City of Mercer Island
9611 SE 36th Street
Mercer Island, WA 98040-3732

October 17, 2019

Attn: Ms. Nichole Gaudette
Senior Planner
Regarding - CAO-19-019

PLANT SCHEDULE - APPROXIMATE

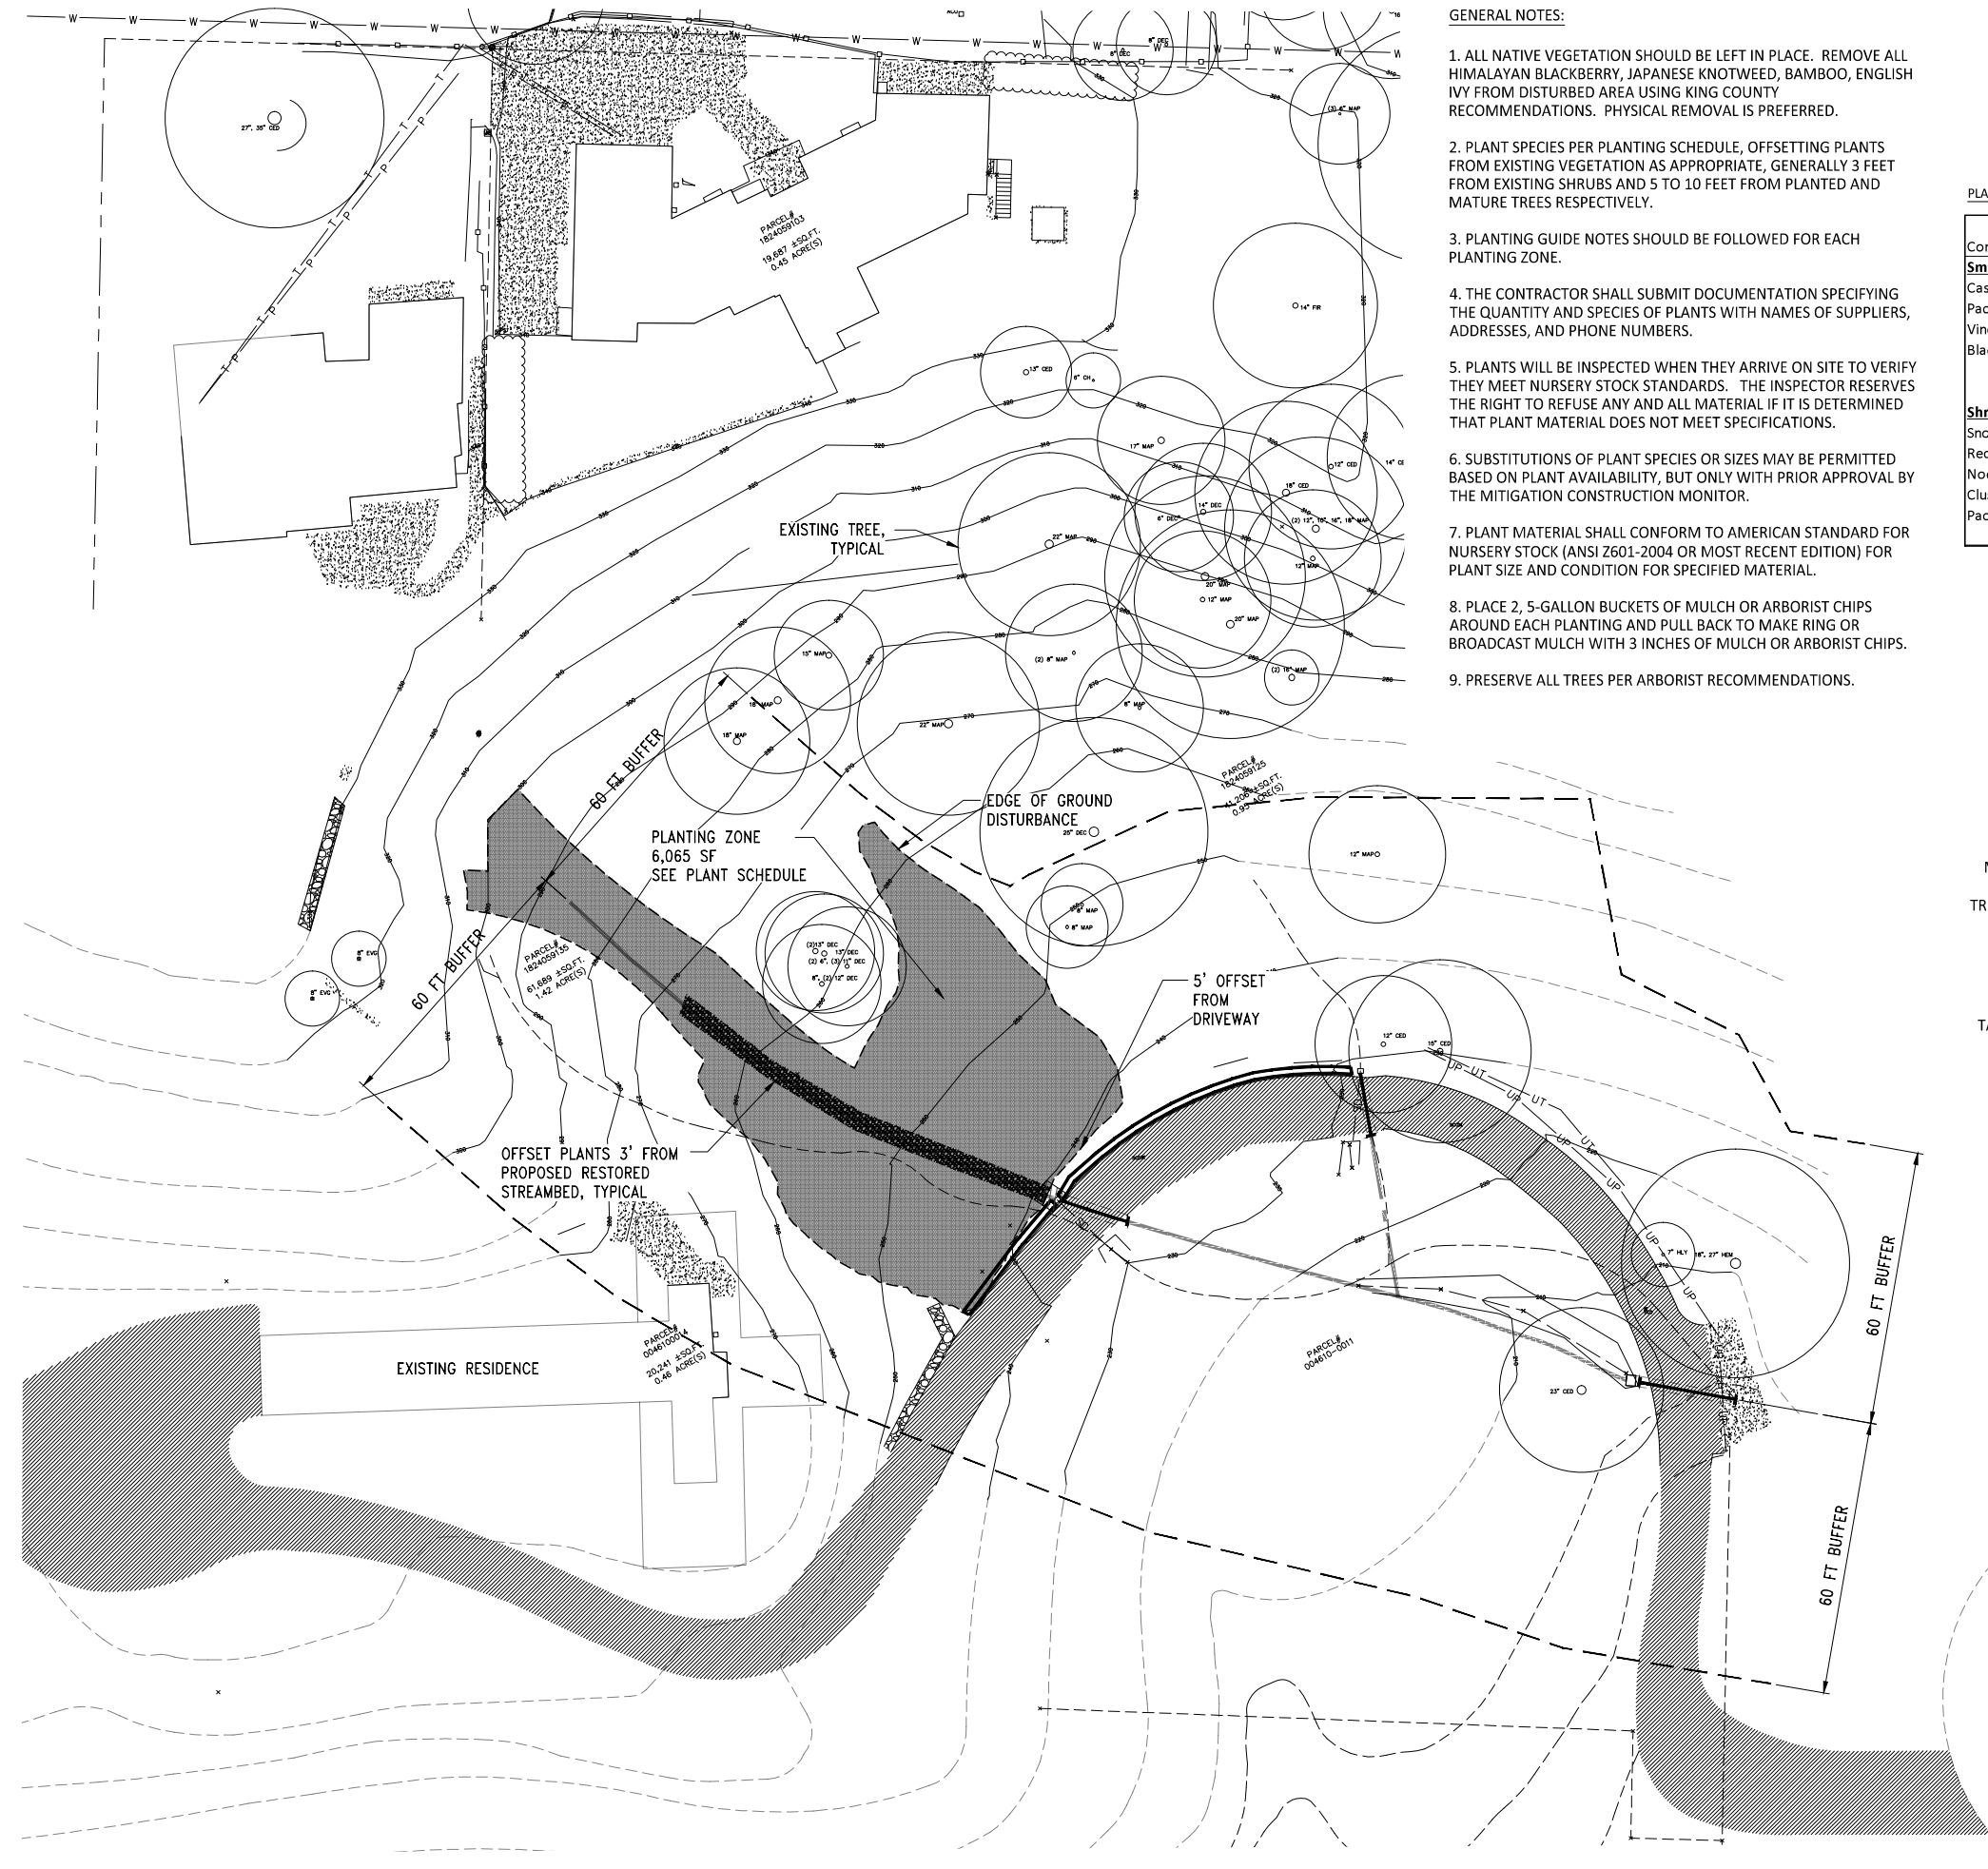
- a. The Pacific Flyway has been added to the SEPA checklist
 7. According to the Slope Re-Vegetation Memo and Planting Plan, many of the proposed plantings include species such as vine maple, serviceberry, snowberry, cascara, and red elderberry, which are characteristically found in drier, upland habitats. Based on our site visit, the areas proposed for planting appeared to be wet throughout the year. Please revise the proposed plant species in the Slope Re-Vegetation Memo and Planting Plan to include species that would successfully establish and improve ecological functions of the re-established stream. Recommended species could include salmonberry, Pacific ninebark, peafruit rose, red-osier dogwood and/or willow.

See attached for revised planting memo and plan.
